From: Simon Davis
Sent: 26 November 2018 14:21
To: Planning.Responses
Subject: FW: BN/52/18/DOC Lake Lane Barnham, Discharge of Planning Conditions 4, 5 & 8.

Laura Gibbons, MEng, GMICE
Engineer (Drainage & Coastal)

Subject: BN/52/18/DOC Lake Lane Barnham, Discharge of Planning Conditions 4, 5 & 8.

Drawing Title
Drainage Strategy
Site Location Plan

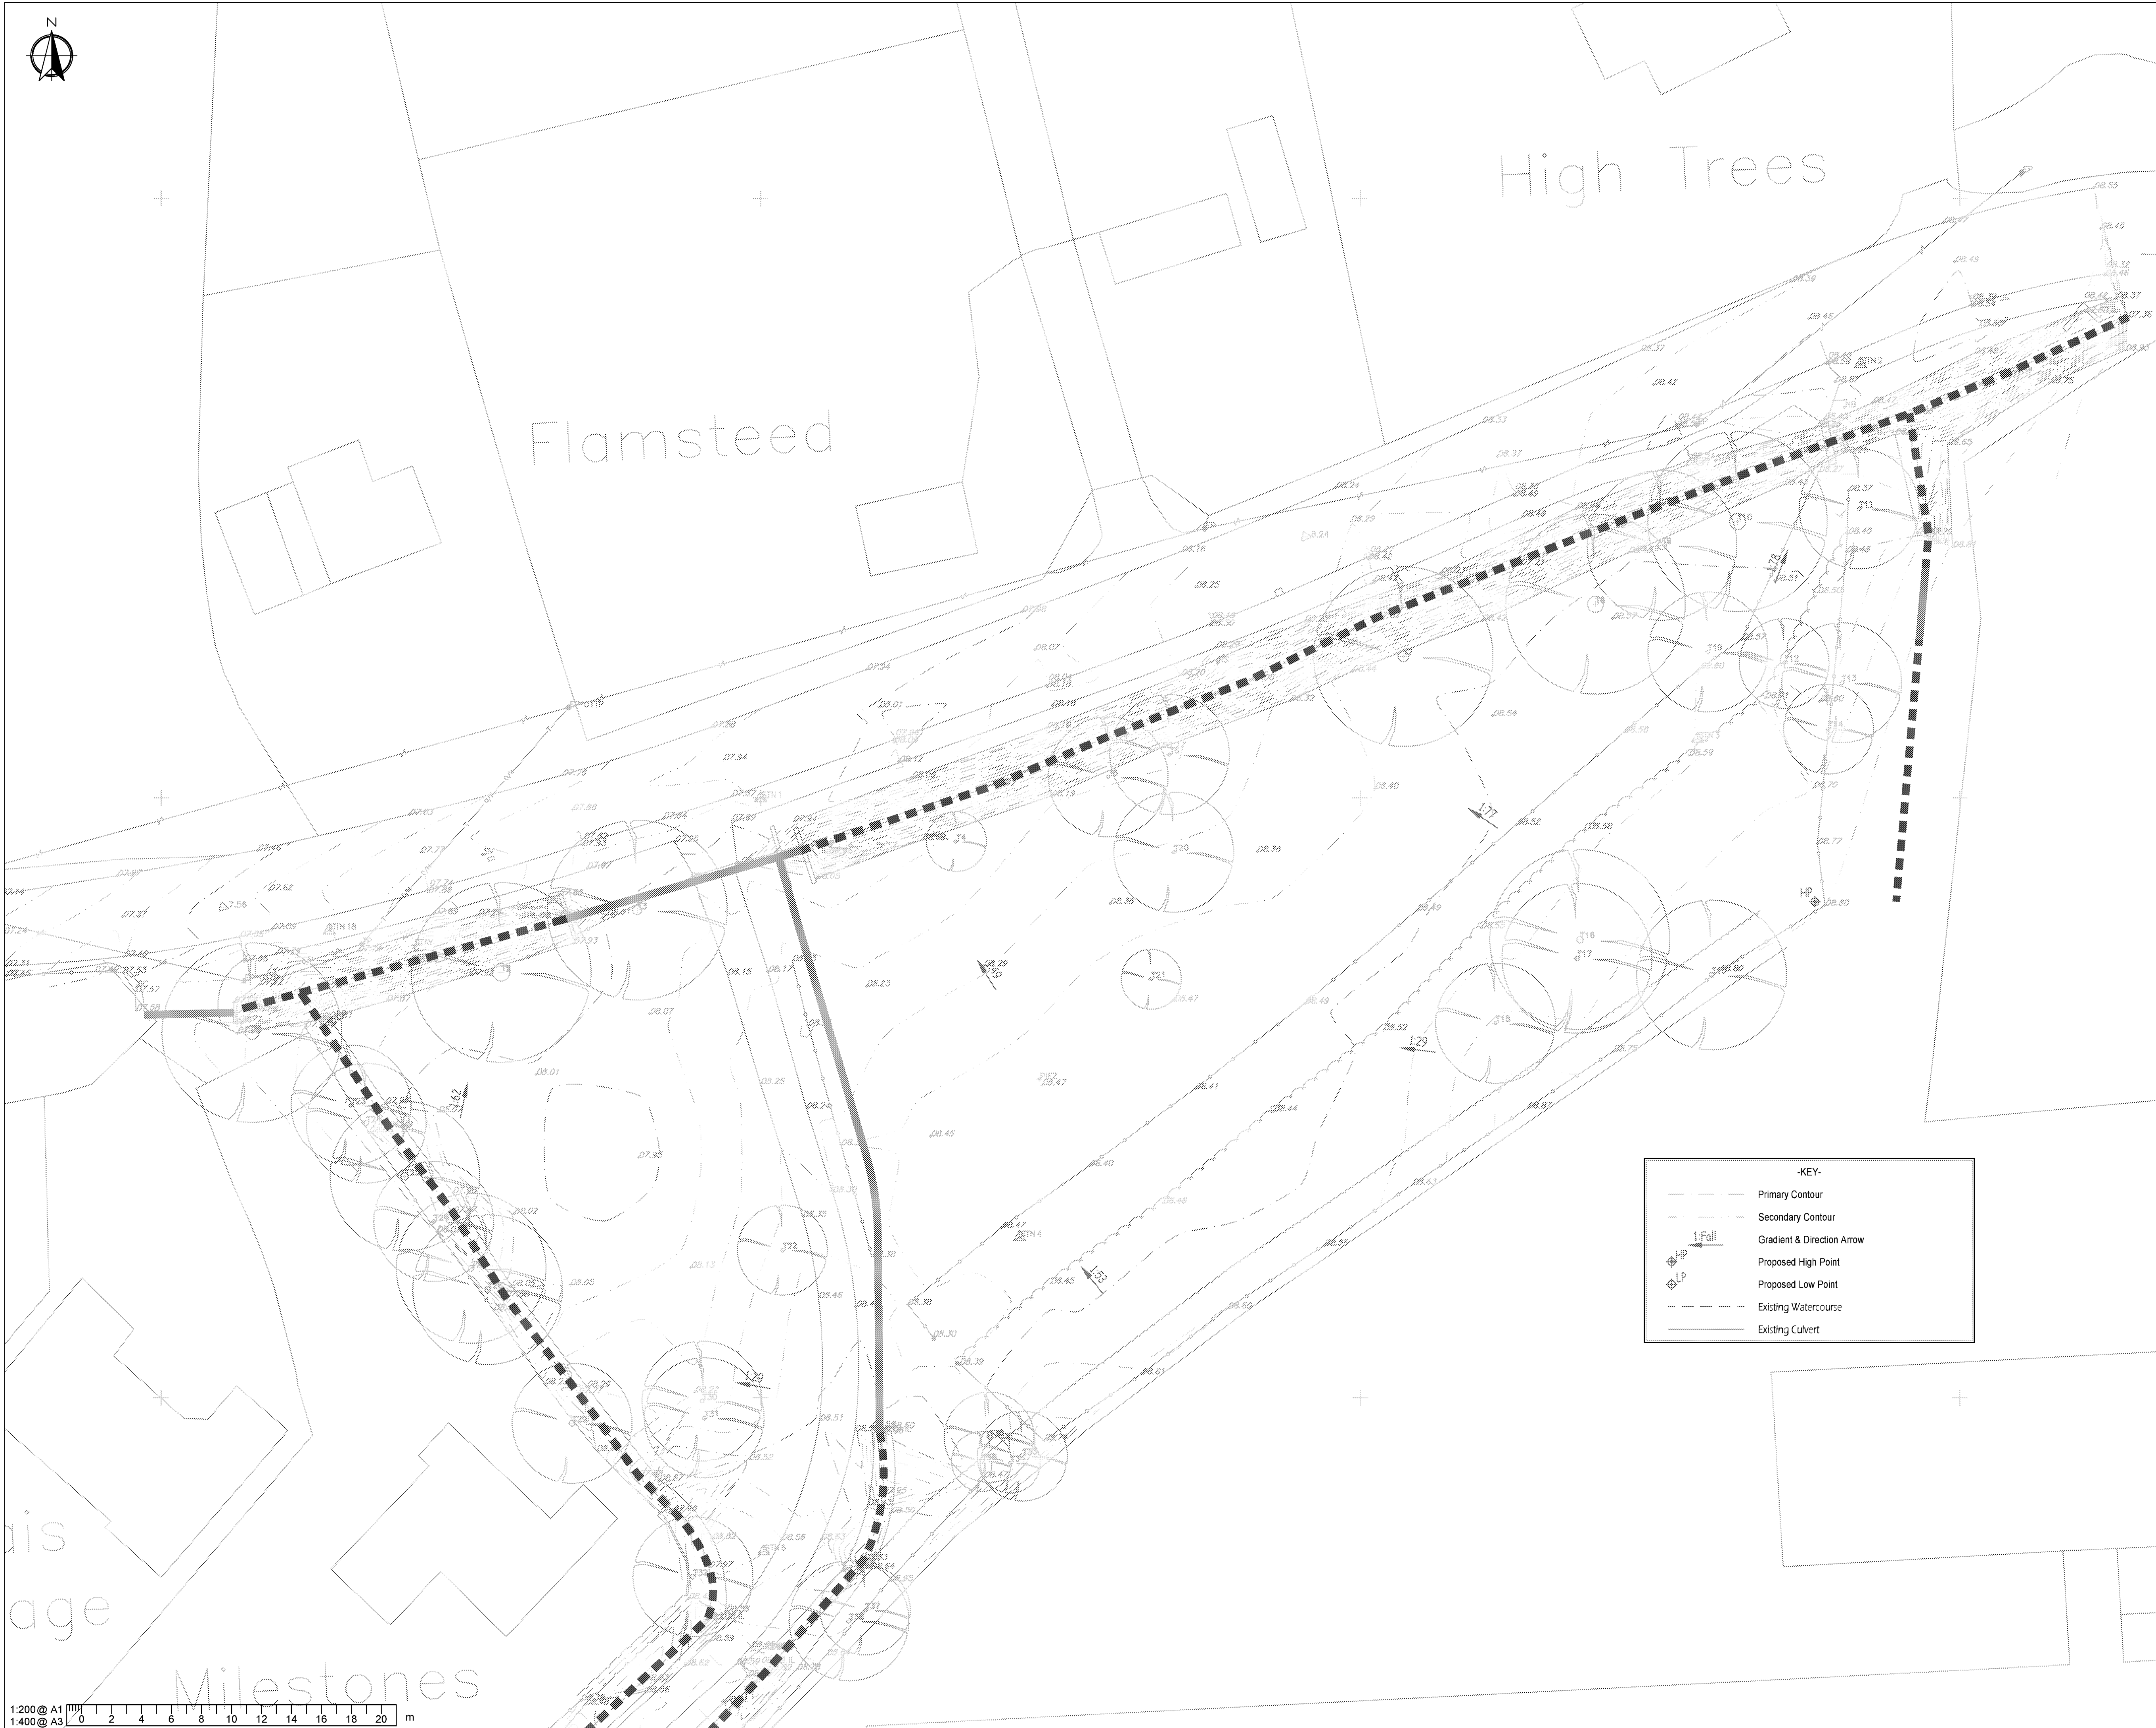
1. The drainage strategy report was approved at planning stage with the 5l/sec flow rate being accepted (Following DEFRA guidance). This is an historic development and was fully approved in principle over 2 years ago and we are merely implementing the approved design. DEFRA guidance is outdated. 5l/s is a significant increase in flow from the existing runoff which is 1.4l/s, this in my opinion would result in flood risk being increased elsewhere. Please revise design for 2l/s outflow.
